SUBJECT: Section 75W modification request for internal and external alterations to Lot 63, 18 Nordica Street and Lot 60, 14 Seamist Avenue, Ermington, Parramatta (MP05 0084 MOD 3, MP05 0084 MOD 4)

To determine the modification requests for internal and external alterations to Lot 63, 18 Nordica Street (Mod 3) and Lot 60, 14 Seamist Avenue (Mod 4), Ermington.

Drawing Title:
FIRST FLOOR PLAN

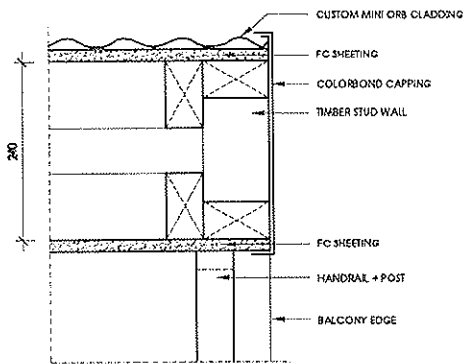
The proposal seeks to increase the floor area by 29.3m² resulting in a gross floor area of 204.7m². This increase will accommodate an addition bedroom and ensuite above the living room on the ground floor. The proposal will enlarge the dwelling from three to four bedrooms. Plans are provided in Tag B.

The Department has considered the potential privacy impact resulting from the proposed second storey windows. The proposed bedroom window has a sill height of 1.5m and looks east onto a blank wall on the adjoining property. The second window is an ensuite window which is small, will be fitted with obscure glazing and does not directly face another window. It is therefore considered that adequate privacy will be maintained between properties.

Drawing Title:
SIDE ELEVATIONS

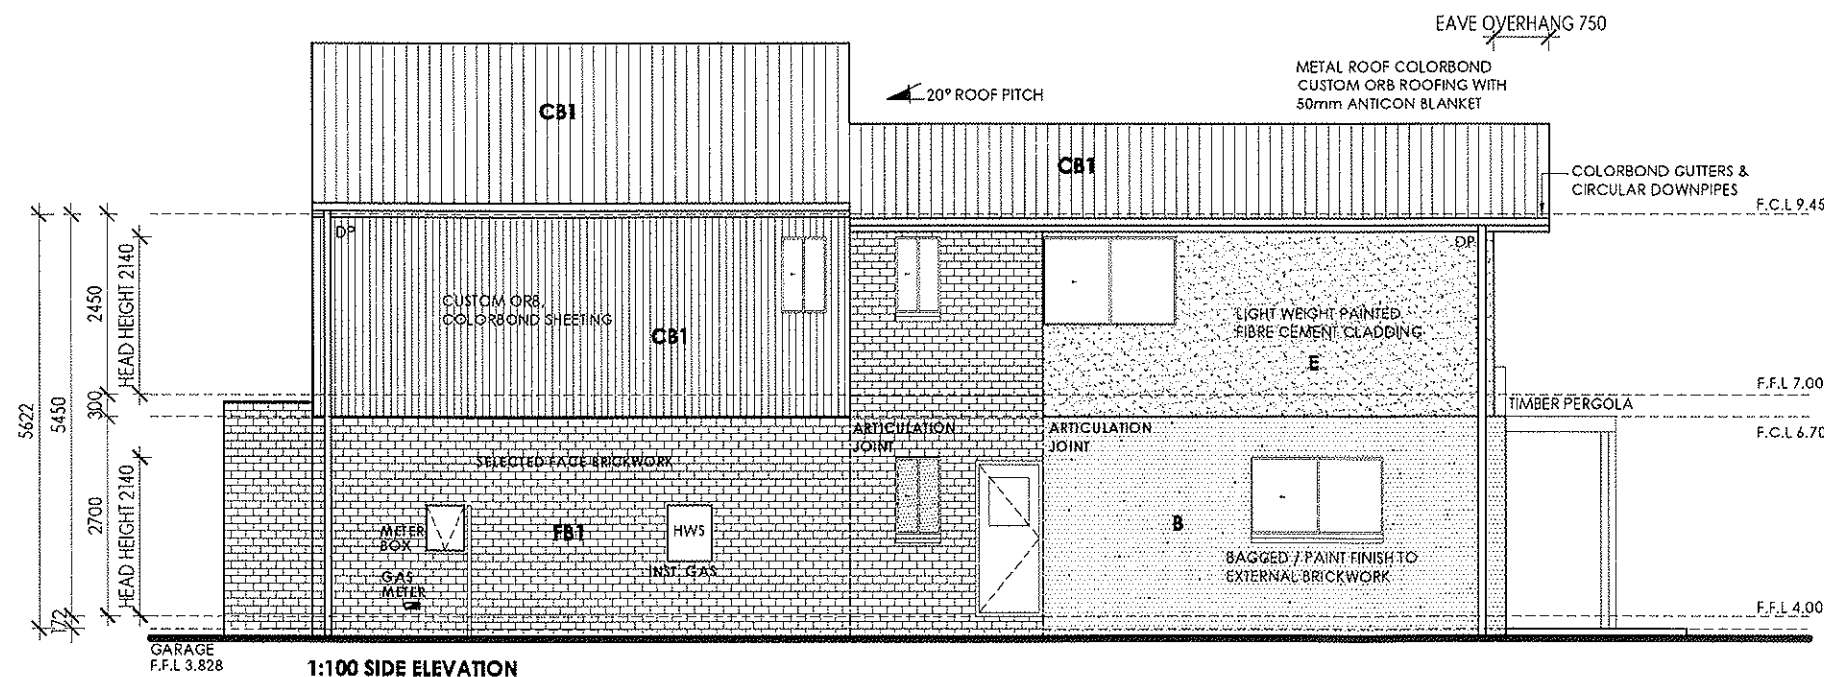
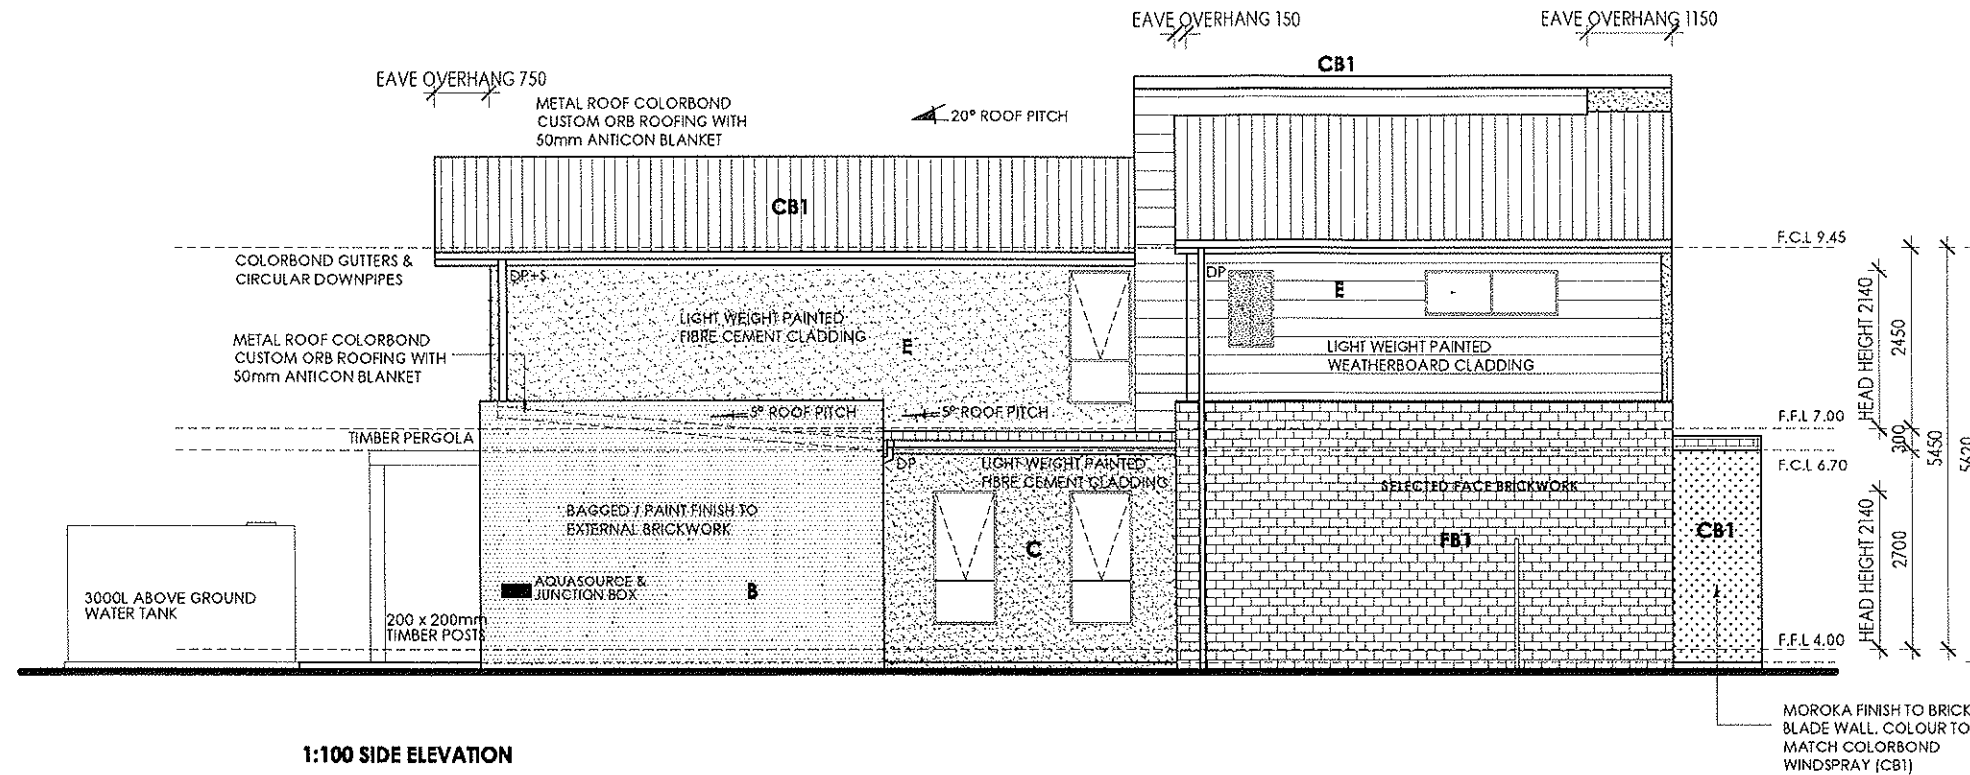
The proposed additional bedroom will increase overshadowing to the neighbouring property to the east just before 3pm and onwards at mid winter. However, given that 2 storey developments is permissible, the orientation of the lot and the previously approved minimal set backs, the minor increase in afternoon overshadowing as a result of the modification is considered to be reasonable.
